From: Anita Gardner
Sent: 10 December 2018 09:56
To: Planning.Responses
Subject: FW: A/114/18/PL Broadlees, Dappers Lane, Angmering

Subject: A/114/18/PL Broadlees, Dappers Lane, Angmering

I write to you in relation to the proposed 70 bed care home development at the Broadlees site on Dappers Lane, Angmering. You will be aware that the site has extant planning consent for a development consisting of 53 No. Care apartments (A/27/16/PL).

Appendix E – Proposed Pedestrian Infrastructure

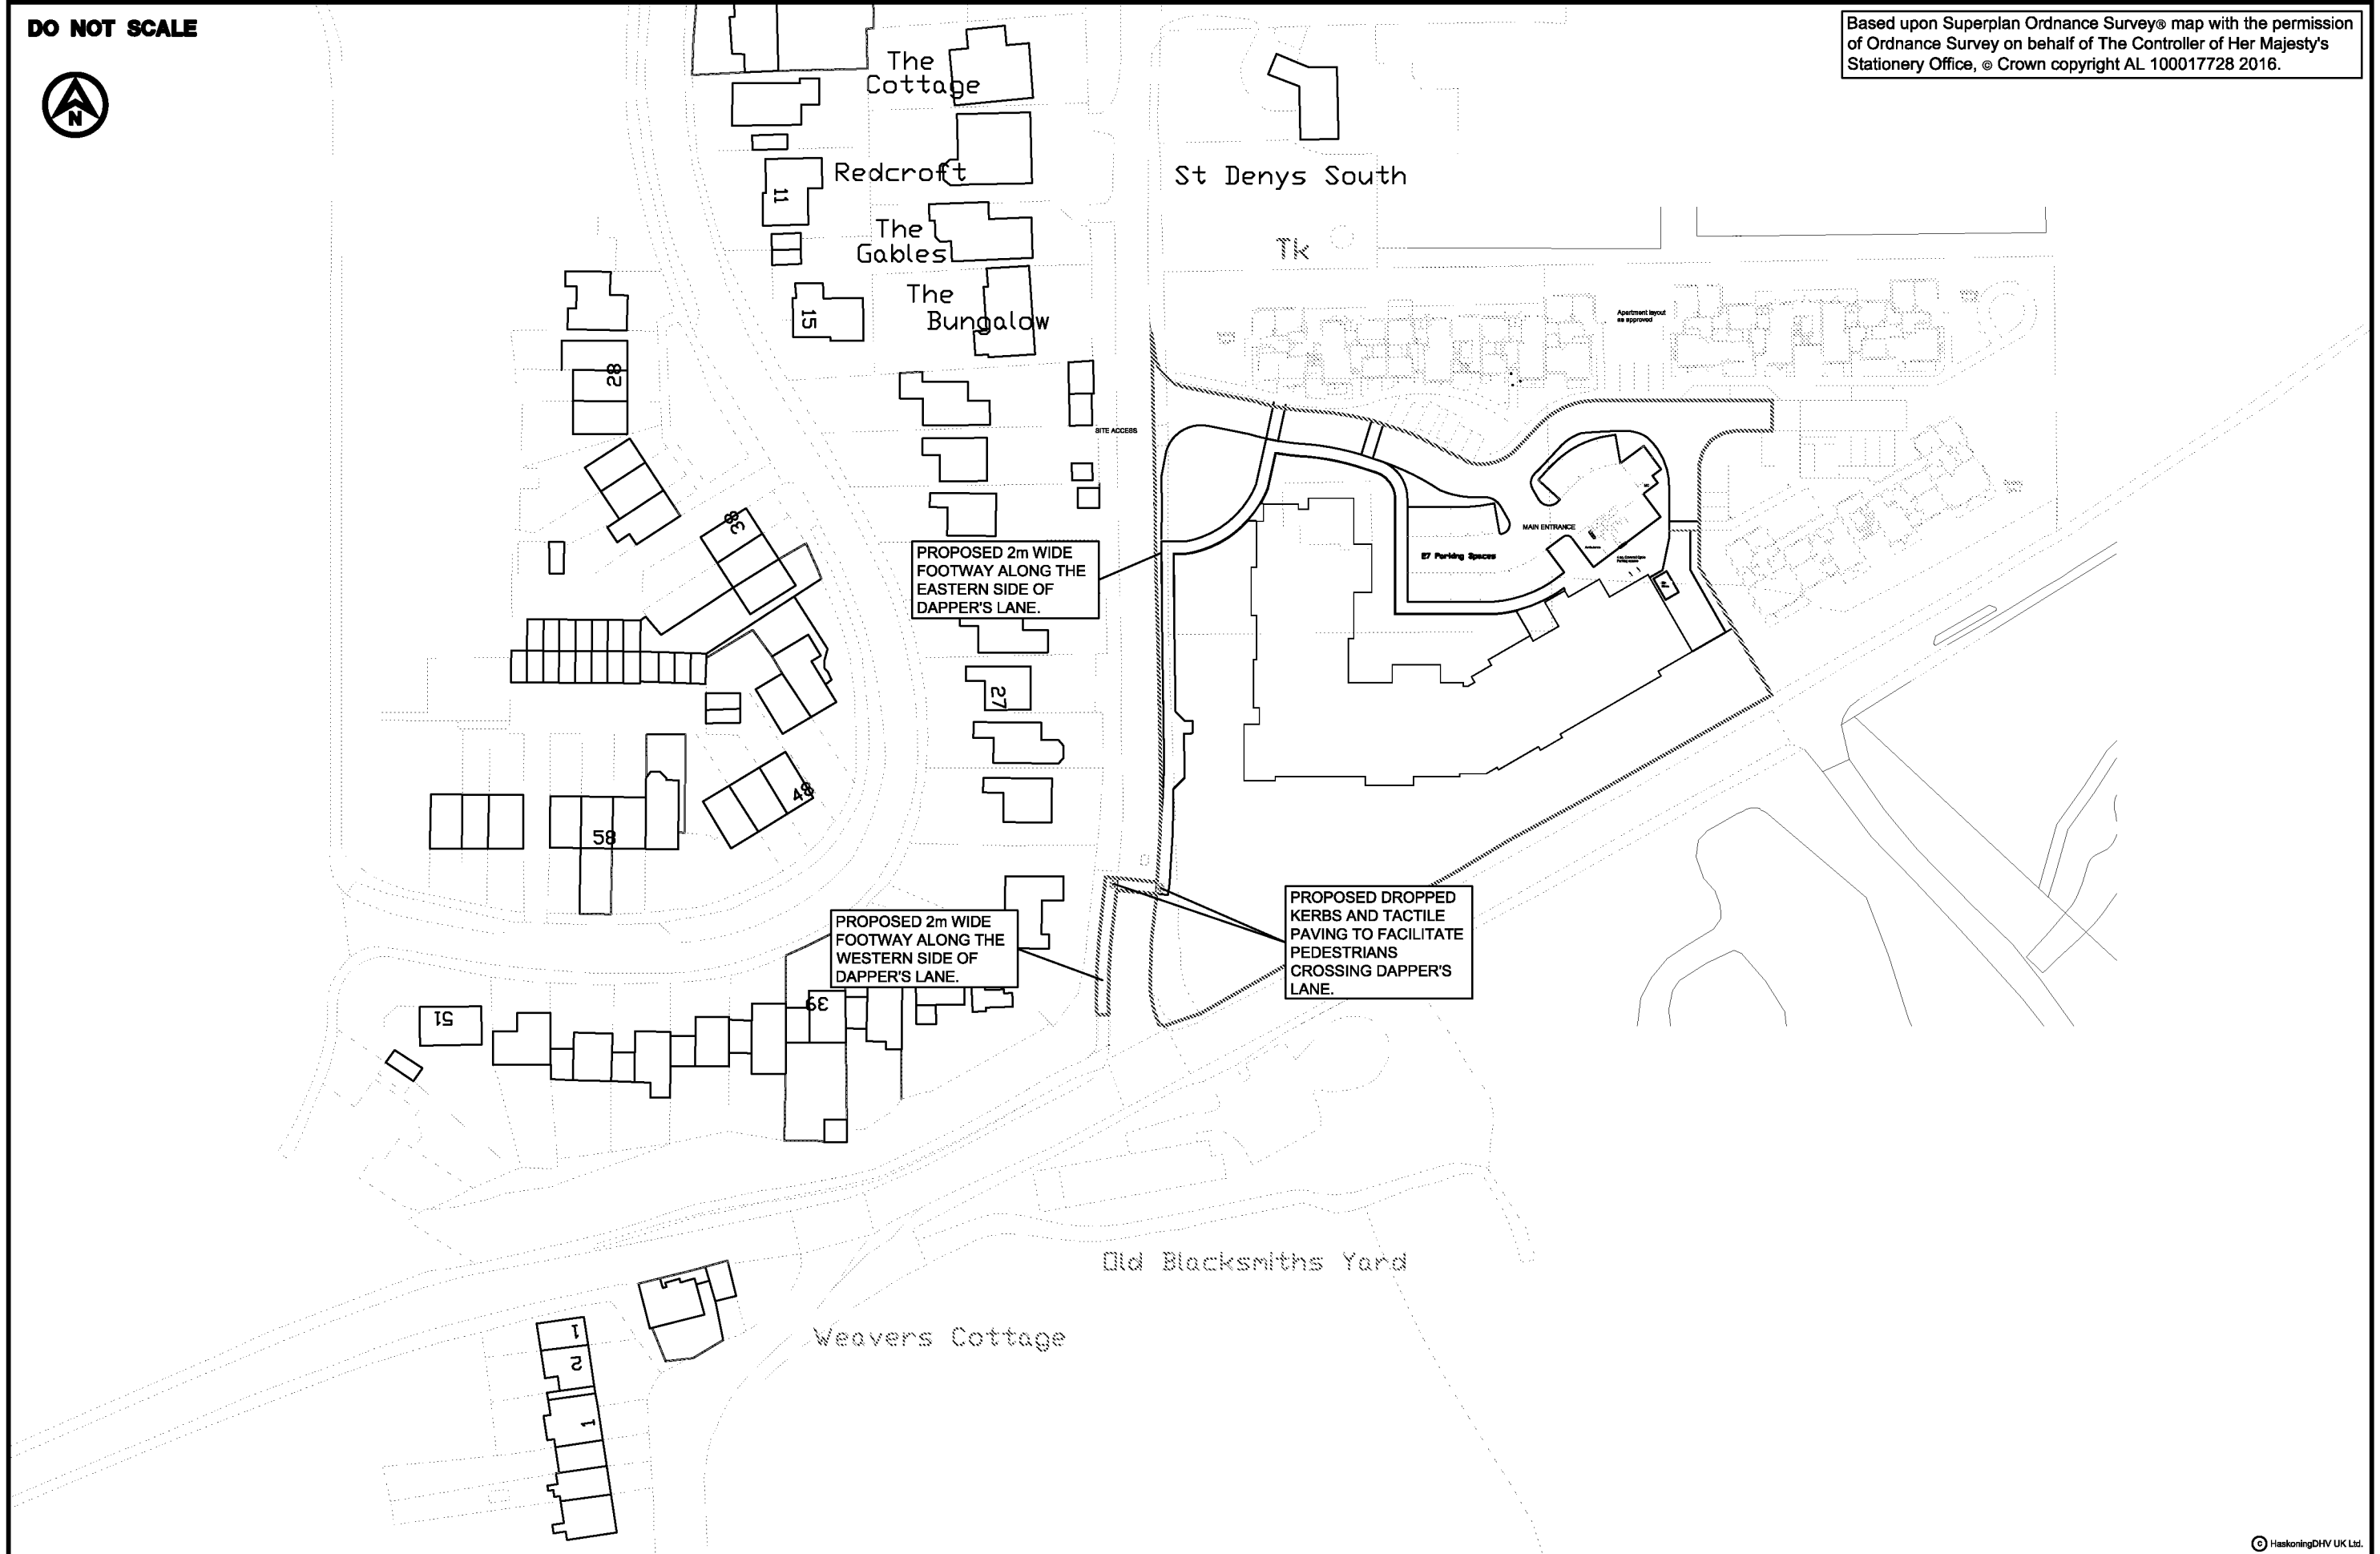
Whilst I believe the provision of a footway along Water Lane would provide some benefits for future residents and employees of the proposed development in conjunction with that proposed as part of planning apps A/99/17 and A/40/18. I am content that the provision of a footway would not be a requirement for this application or reason for refusal.

In relation to the off-site pedestrian infrastructure proposed, the construction of a footway and informal pedestrian crossing is agreed as per the extant consent and presented within attached plan **PB7693-SK01**. In your response you make reference to the adjacent planning application sites proposed by Gleeson/Rydon Homes:
